Application for a Non-Material Amendment Following a Grant of Planning Permission Town and Country Planning Act 1990 (as amended)

ERECTION OF TWO STOREY SIDE EXTENSION AND EXTENSION TO EXISTING PORCH (WITHIN A CONSERVATION AREA)

2025/62/92104/W

- 1- A window to be placed on the side elevation of the ground floor
- 2- Previously approved Set back at first floor to be brought forward

CLIENT	Mr Jamil Akhtar		
ADDRESS	50 Birkby Lodge Road HD2 2BG, Huddersfield		
PROJECT	Two Storey Side Extension		
DRAWING	Non Material Amendment		
DRAWN	UH	DATE	July 25
SCALE	1.50@A1		
DWG No.	2224/04D		
STATUS	PLANNING

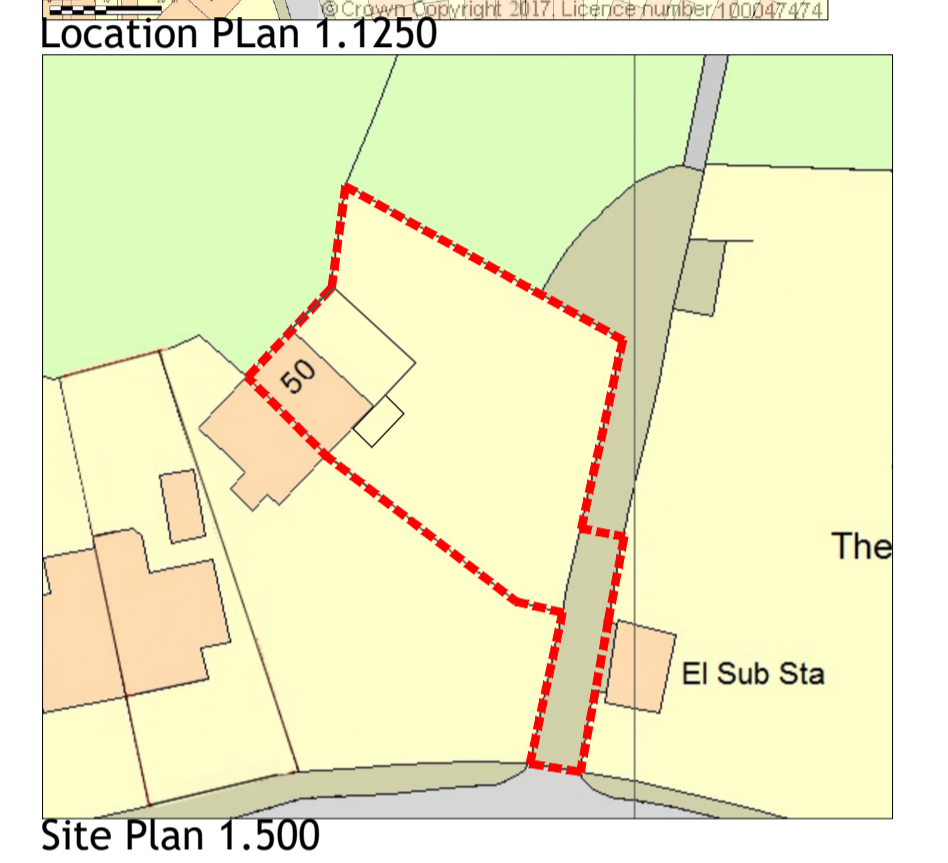
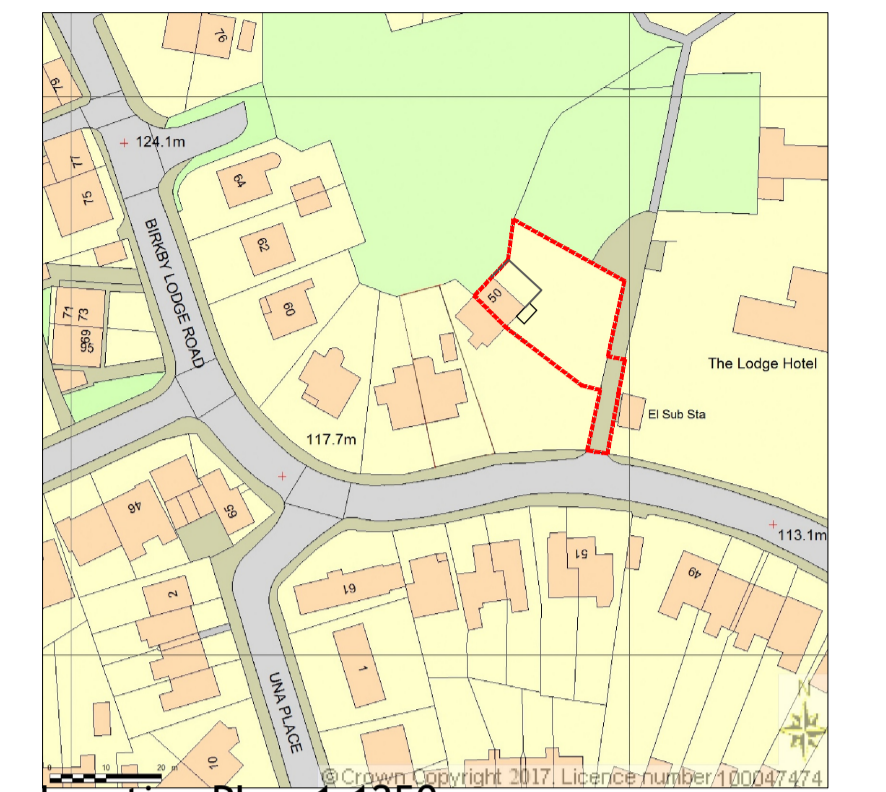
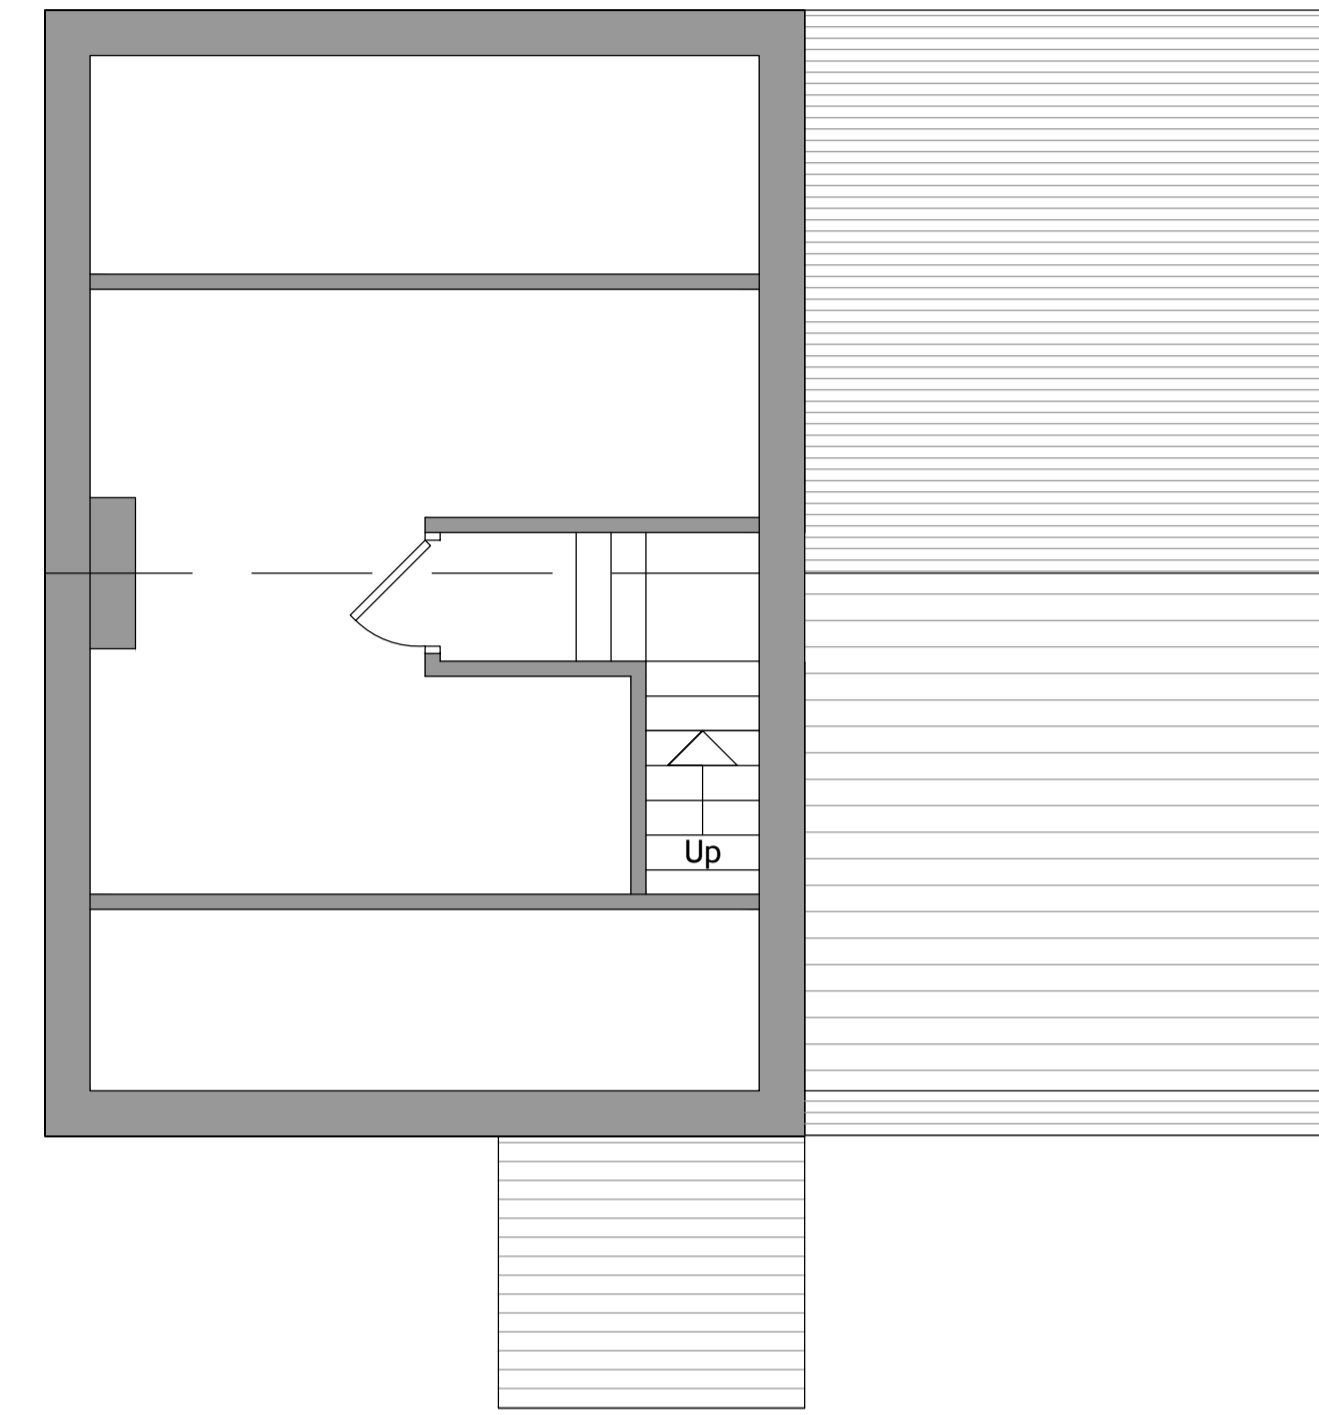
- 1-To allow light into the room and view out into the garden area for safety of children whilst playing and views.
- 2-The circumstances for the applicant have changed, original proposal created a landing area for the new formed bedroom. Due to physical difficulties direct access from the landing is required for bedroom 2. Bedroom 1 is also required for ease of access for another family member. (Medical evidence can be provided if required). The physical issues are expected to increase with age.
